RESIDENT PARKING
CHISHOLM CARRIAGE LOT
ON CHADWICK STREET

APPLICATION FOR CERTIFICATE OF OCCUPANCY FOR USE OF PREMISES

92-96 Chadwick St.

Building permit to construct a parking lot for 22 cars on land owned and contiguous to the Thomas House Interns Residence to which this parking is accessory is being issued subject to the following:

MAINE MEDICAL CENTER	
92-96 CHADWICK RESIDENT PARKING CHISHOLM-CHADWICK ST	
DRWG:	
DR. BY: D.W.B.	DATE: 5/31/67
REV. 6/1/67	SCALE: 1" = 16'

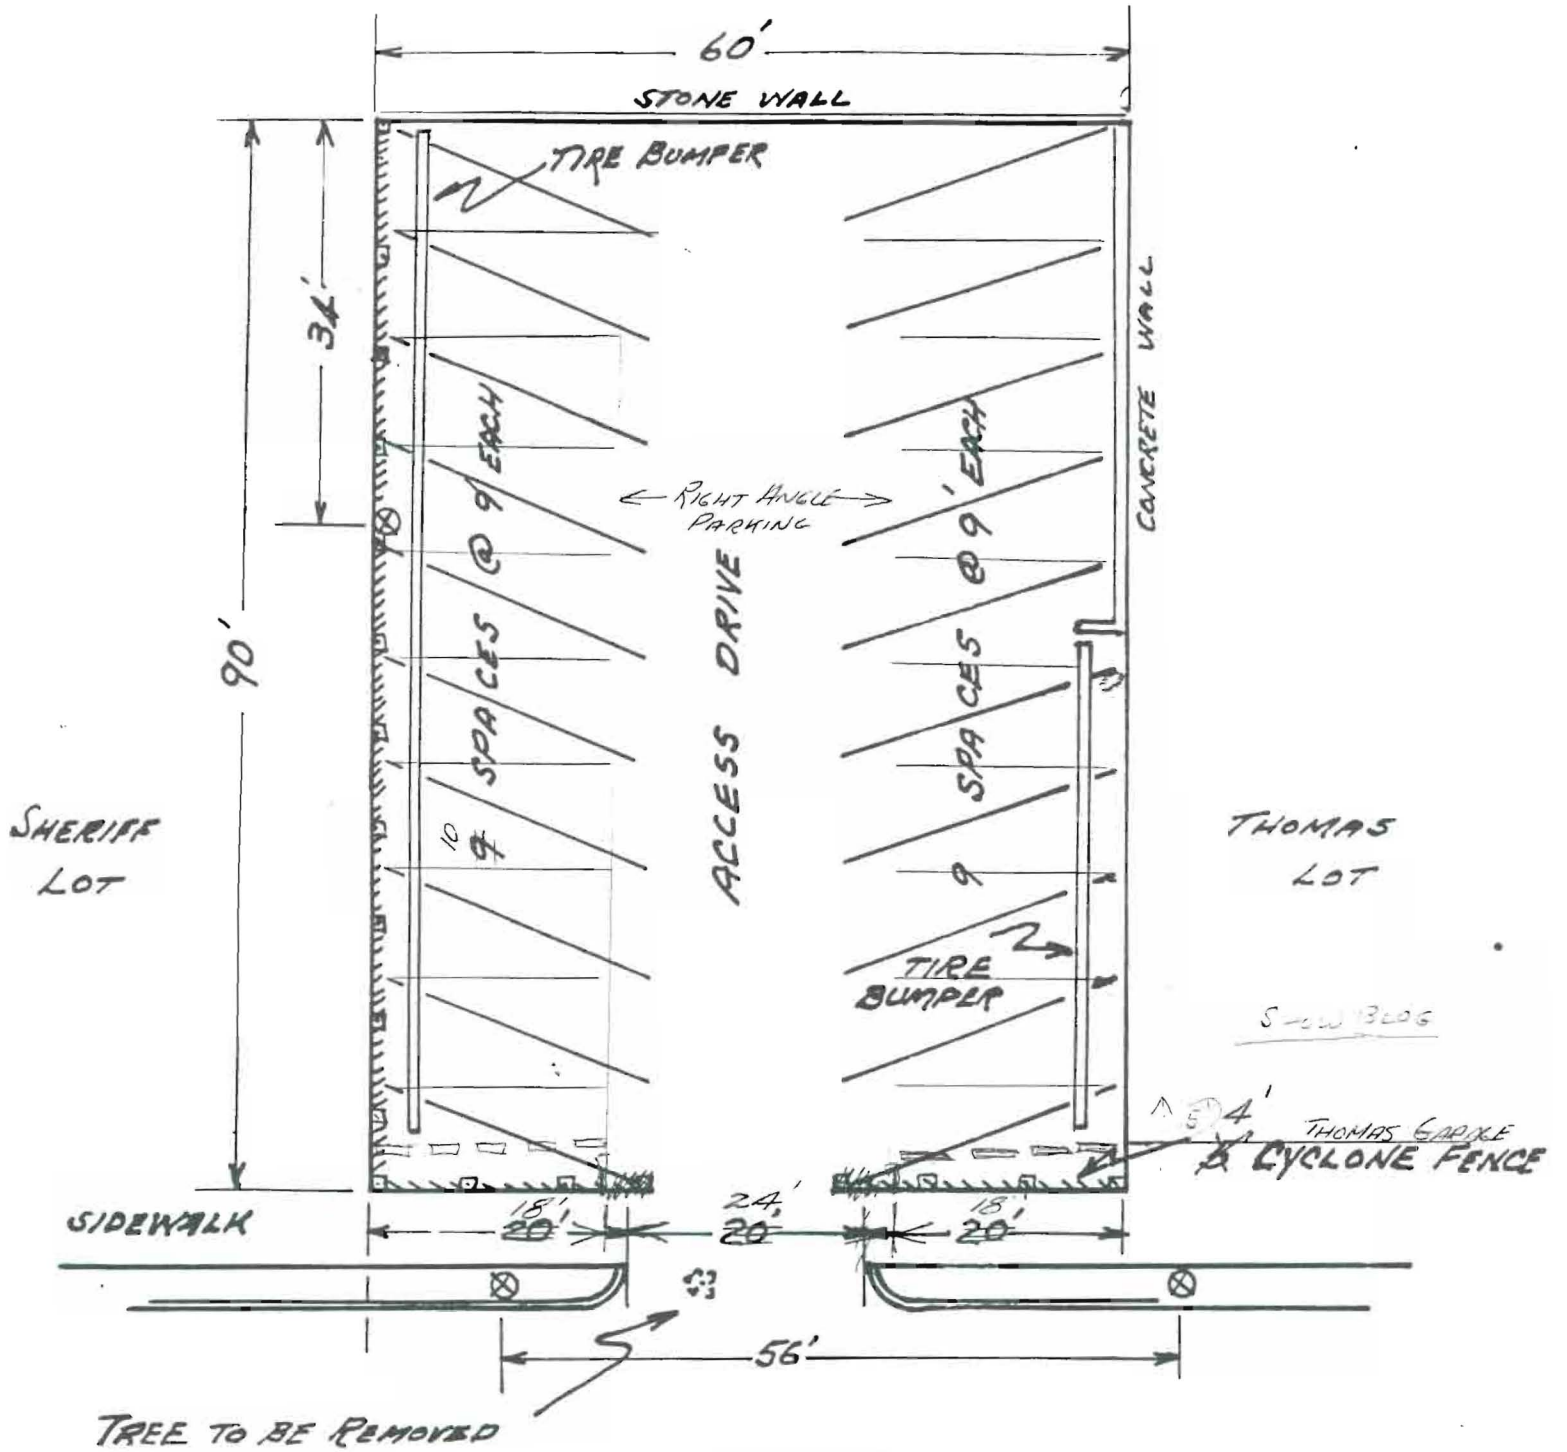
The cyclone fence required by the Zoning Ordinance is to be 4 feet in height along the Chadwick Street line and not over 4 feet in height within 25 feet of this line.

The enclosed is a sketch which is an addendum to the previous sketch on Resident Parking at 92-96 Chadwick Street, and it shows the requested 5 foot spacing between the first right angular parking space and the edge of the sidewalk.

Your letter and authorization to proceed with the parking lot at 92-96 Chadwick Street has been received, and the exception in relation to the cyclone fence has been noted and will be complied with.
